KIRKLEES METROPOLITAN COUNCIL INVESTMENT & REGENERATION SERVICE

Reference No:	2026/70/90740/W
Site Address:	Part of former St Luke's Hospital site, Blackmoorfoot Road, Crosland Moor, Huddersfield, HD4 5RA
Description:	Variation of conditions 2 (plans), 12 (retaining walls), 17 (carbon emissions), 18 (crime mitigation strategy), 19 (landscaping), 20 (noise assessment), 21 (materials), 23 (boundary treatments) and 32 (delivery noise management plan) on previous permission 2023/91405 for erection of foodstore (class E) with associated access, parking, servicing area and landscaping
Recommending Officer:	Ellie Thornhill

Officer report

Proposal: Variation of conditions 2 (plans), 12 (retaining walls), 17 (carbon emissions), 18 (crime mitigation strategy), 19 (landscaping), 20 (noise assessment), 21 (materials), 23 (boundary treatments) and 32 (delivery noise management plan) on previous permission 2023/91405 for erection of foodstore (class E) with associated access, parking, servicing area and landscaping

PROPOSED STONE RETAINING WALL
SCALE 1:50
WITH ASHLAR STONE CAPPING FINISH (TO STRUCTURAL ENGINEER DESIGN AND DETAILS) WITH 1100MM DARK GREY METAL FENCE/GUARDING ON TOP. (RETAINING WALL HEIGHT VARIES)

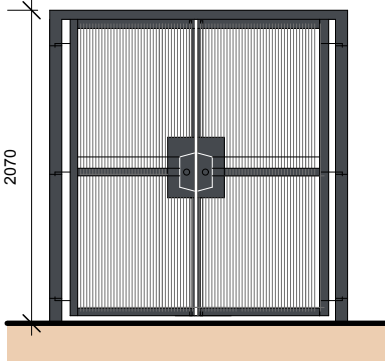
KC Highway Structures: I would like to advise that condition 12 (retaining walls) should be reimposed.

In this case, given the close relationship to which the new building would have with the proposed retaining wall along Turnstone Way, any excavation to facilitate these works, could have the potential undermine the build for the retaining wall and therefore, officers are not satisfied with the revised wording proposed.

“12. Prior to development commencing (other than site clearance works that would not include any excavation works)” , a scheme detailing locations and including cross sectional information together with the proposed design and construction details for all new retaining walls / building retaining walls adjacent to the existing / proposed highways shall be submitted to and approved in writing by the Local Planning Authority. Thereafter, the development shall be undertaken in accordance with the approved details, which shall thereafter be retained.

The agent has confirmed in writing their agreement to the above proposed wording of condition 12.

SECTION C-C
SCALE 1:200

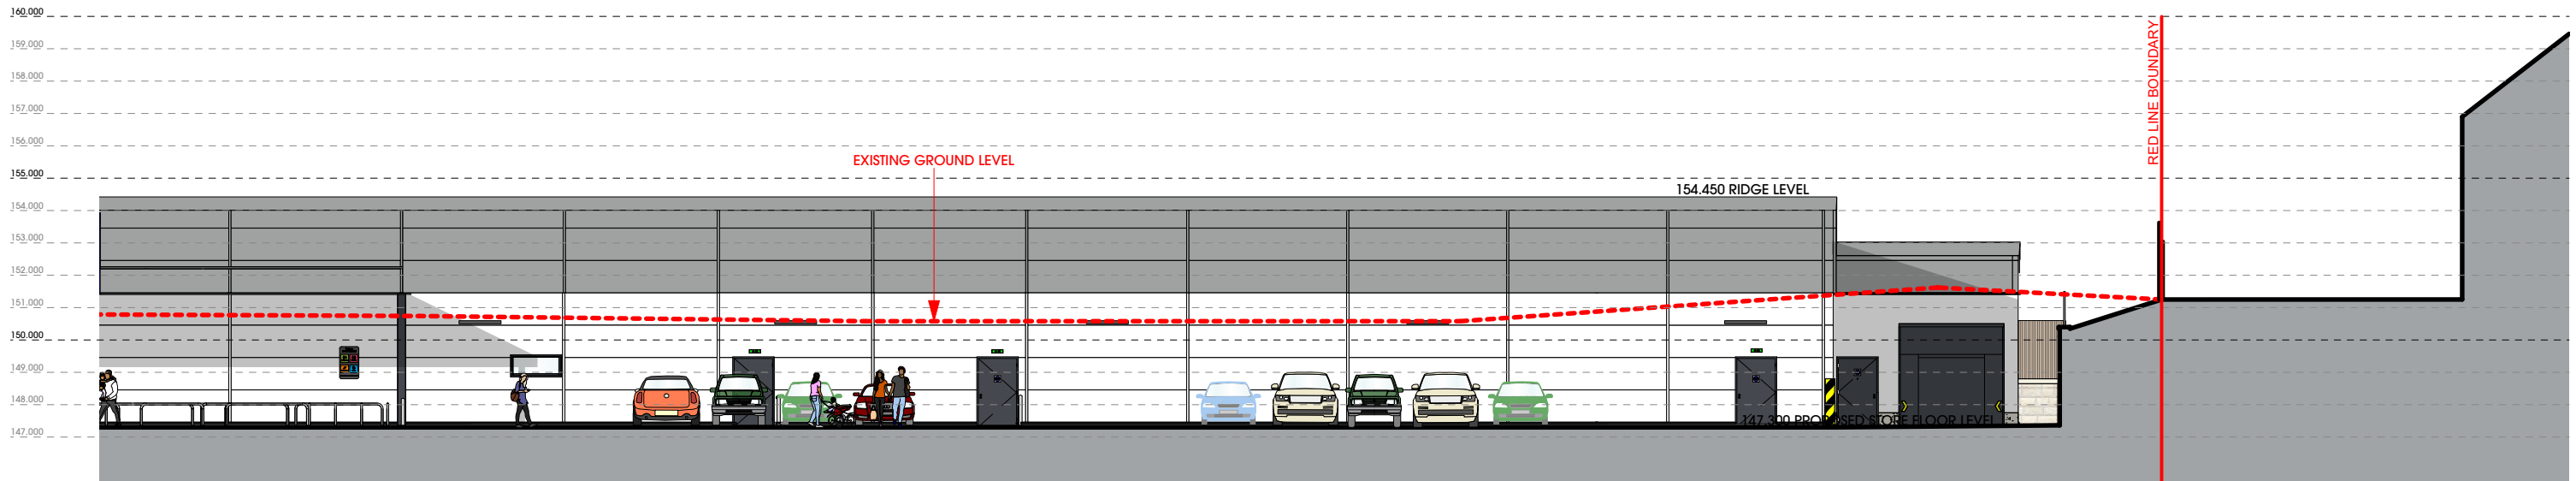
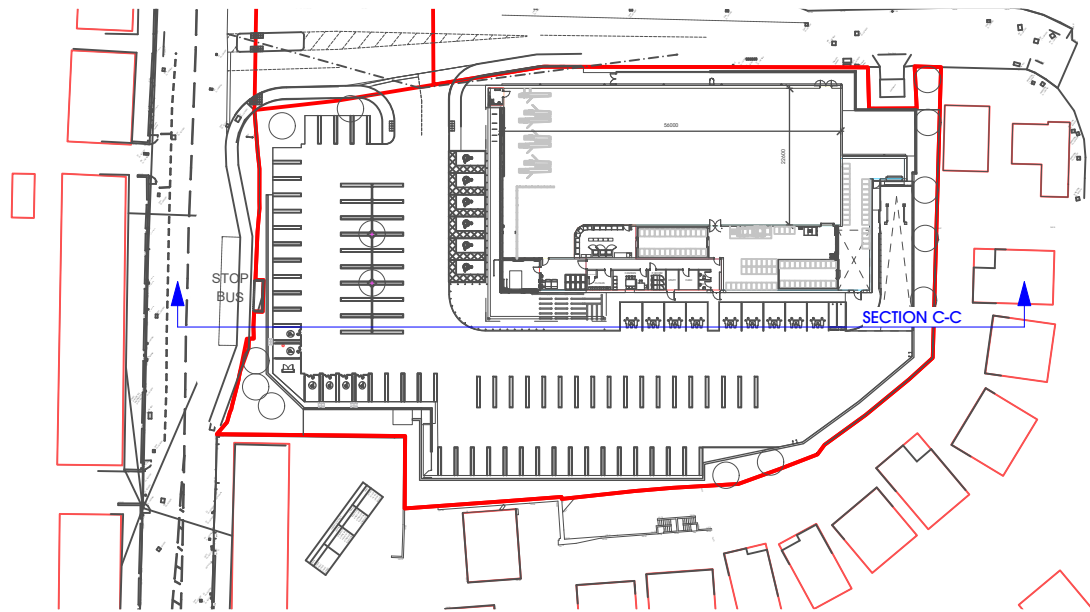
Section plans AA, BB and CC have been submitted to show the relationship the development would have with the aforementioned residential properties along Turnstone Way.

Section plans AA and BB focus on the residential dwellings to the west/south west of the site. On review of these plans, officers are satisfied that

significant separation distances would be retained, along with a reasonable height difference which would mean that these residential properties would remain on a higher level than the application site. The site / proposed building as approved sat on a significantly lower ground level than these dwellings, which would remain the case, despite the 300mm increase.

The slight (300mm) increase in the overall height of the boundary treatment closest to these neighbours as a result of raising the site levels, is also not considered to give rise to any material overbearing or overshadowing. Therefore, officers are satisfied that the changes proposed would have an acceptable impact on these neighbours' amenity.

Client	LiDL		
Project	LiDL Blackmoorfoot Rd Huddersfield		
Drawing title	Proposed Levels		
Drawn	CG	Chkd	PB
Sheet Size	A1	Drawing No.	21561-DR-C-0110
		Date	November 2025
		Scale	1:200
		Revision	P06

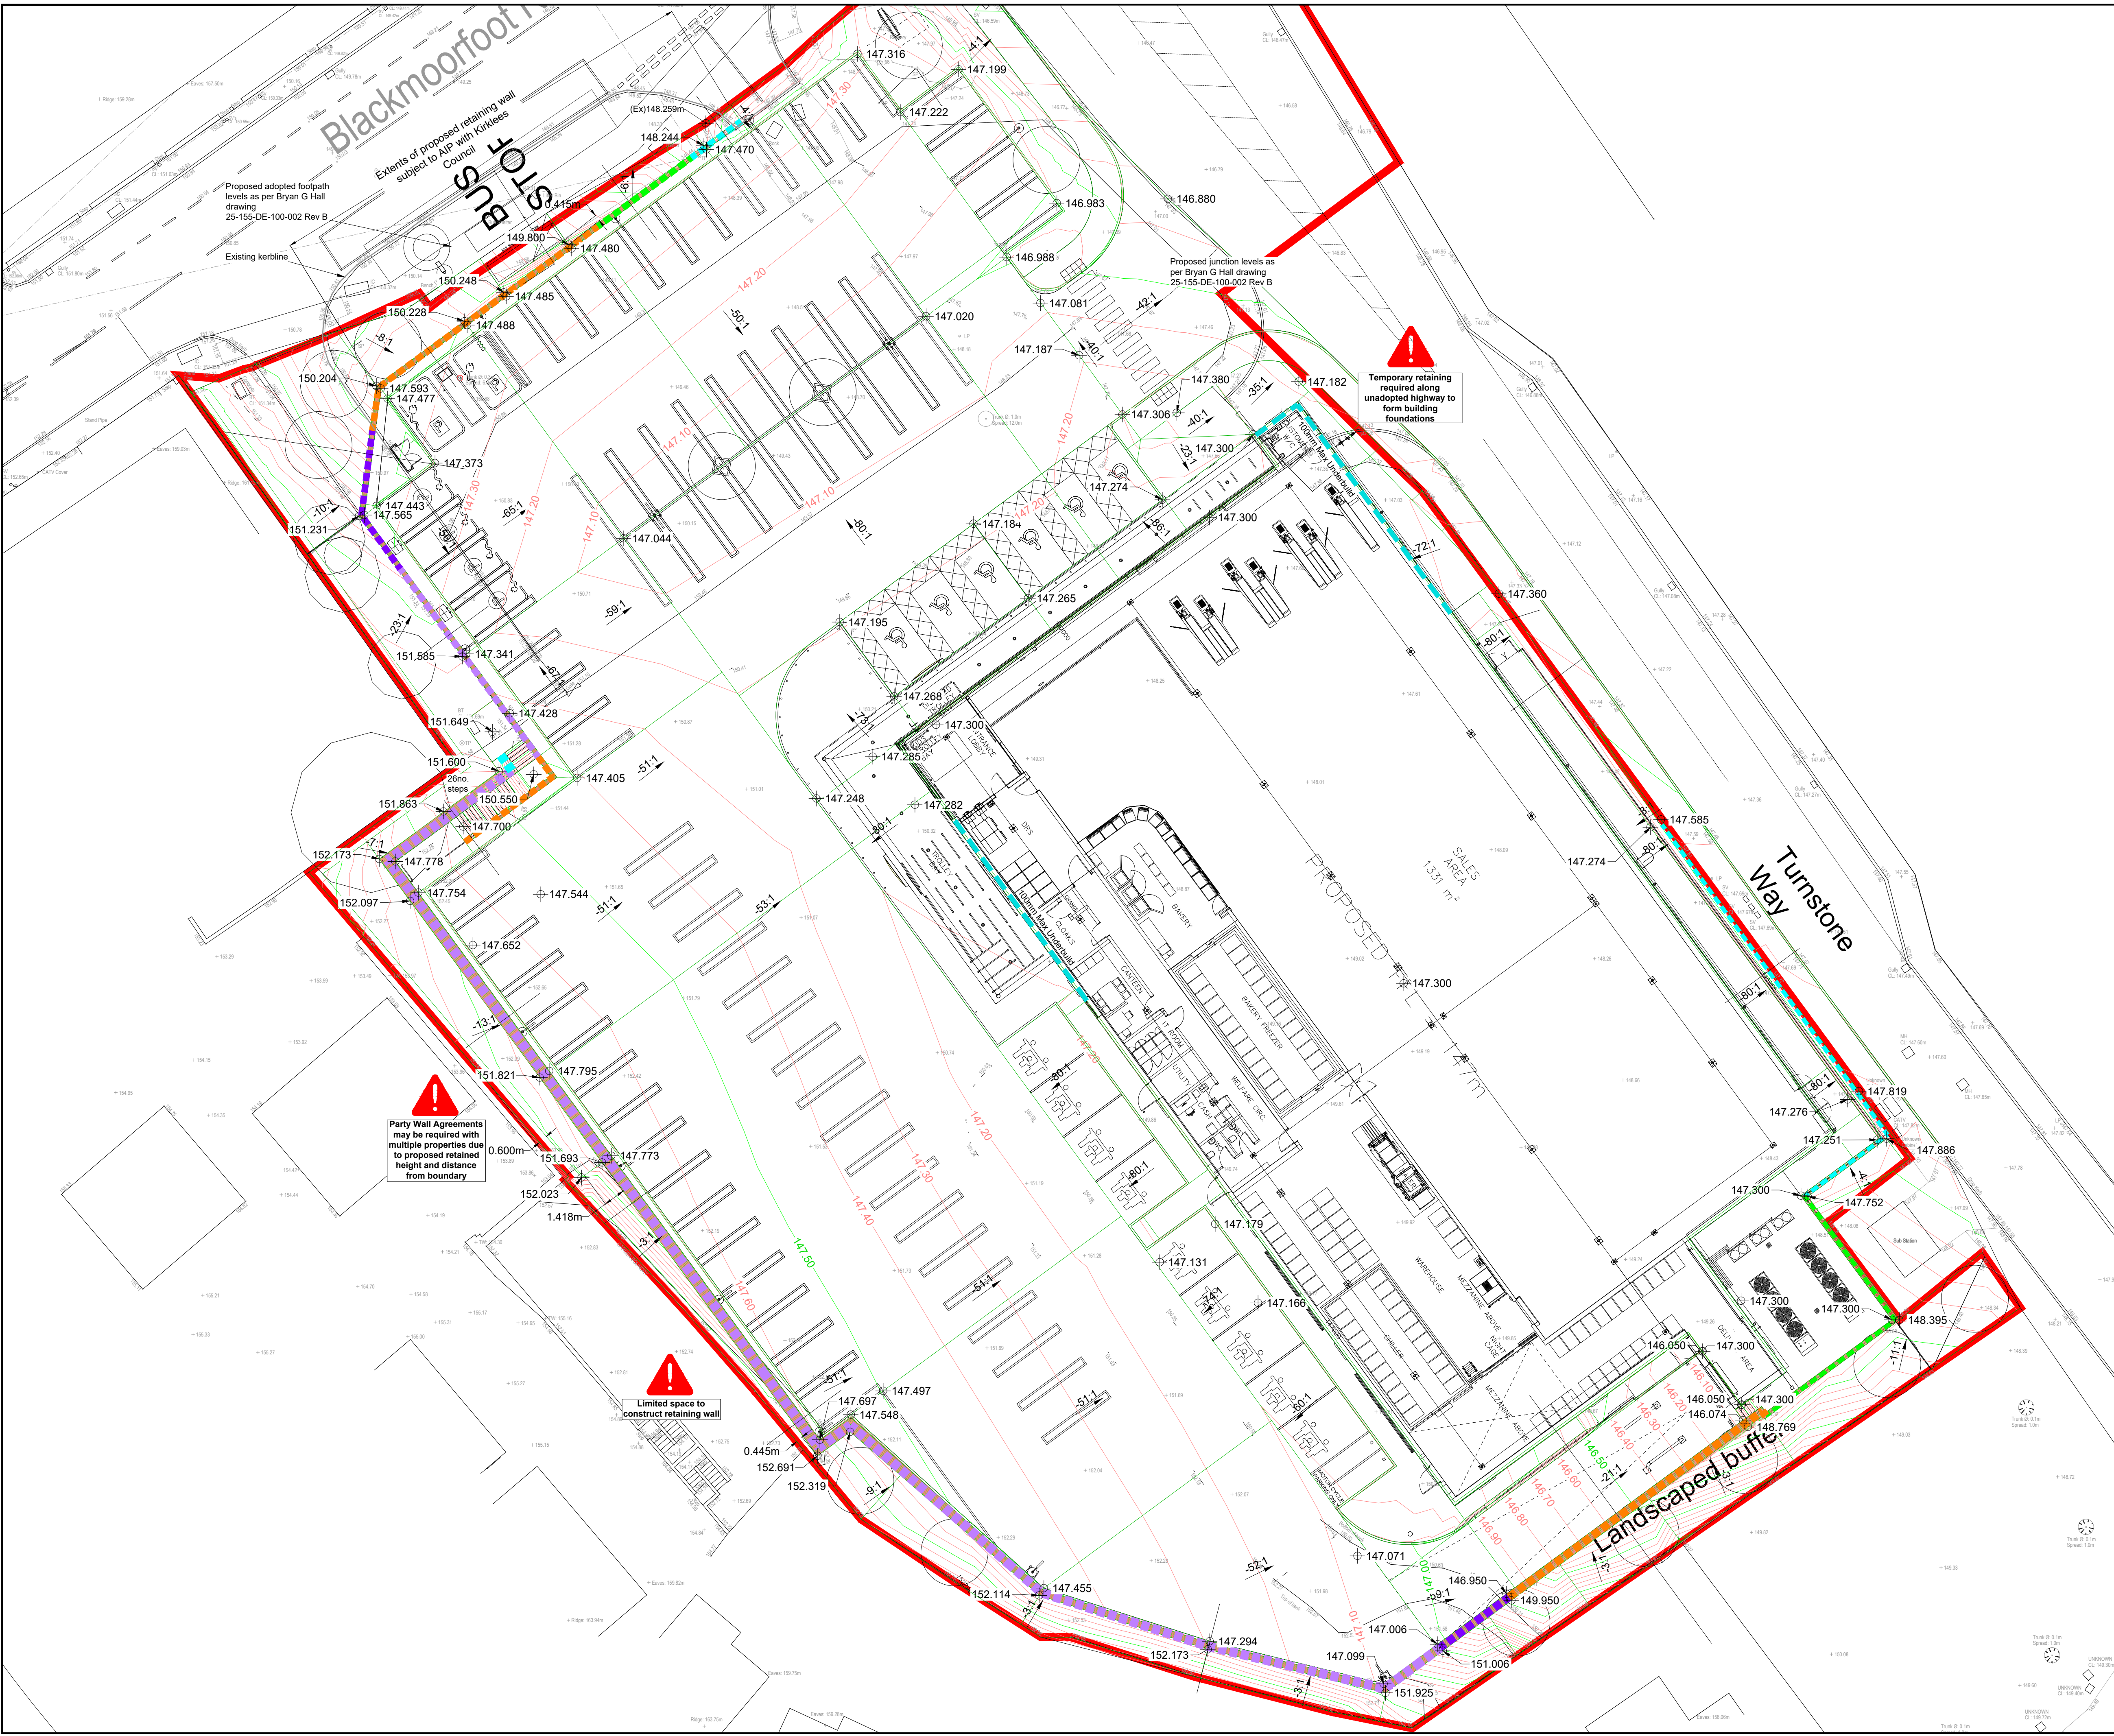
- Increase the finished floor levels (FFL) by 300mm across the site, to allow for the necessary changes to the site levels which are required particularly for the site access and in front of the store to enable the bellmouth at the site access to be adopted by the Local Highway Authority.

The amendments proposed are not considered to give rise to any highway concerns, as the access remains unchanged, along with the parking arrangements. The increase in site levels by 300mm has been requested by the Local Highway Authority, to aid adoption. This is to accord with Policy LP21 of the Kirklees Local Plan and the aims of the National Planning Policy Framework.

As part of the above changes to the levels within the site, details pursuant to conditions 9 (temporary drainage) 15 (flood routing) and 16 (drainage scheme) have also been submitted with this application. These have been reviewed by KC Lead Local Flood Authority and have been considered to be acceptable.
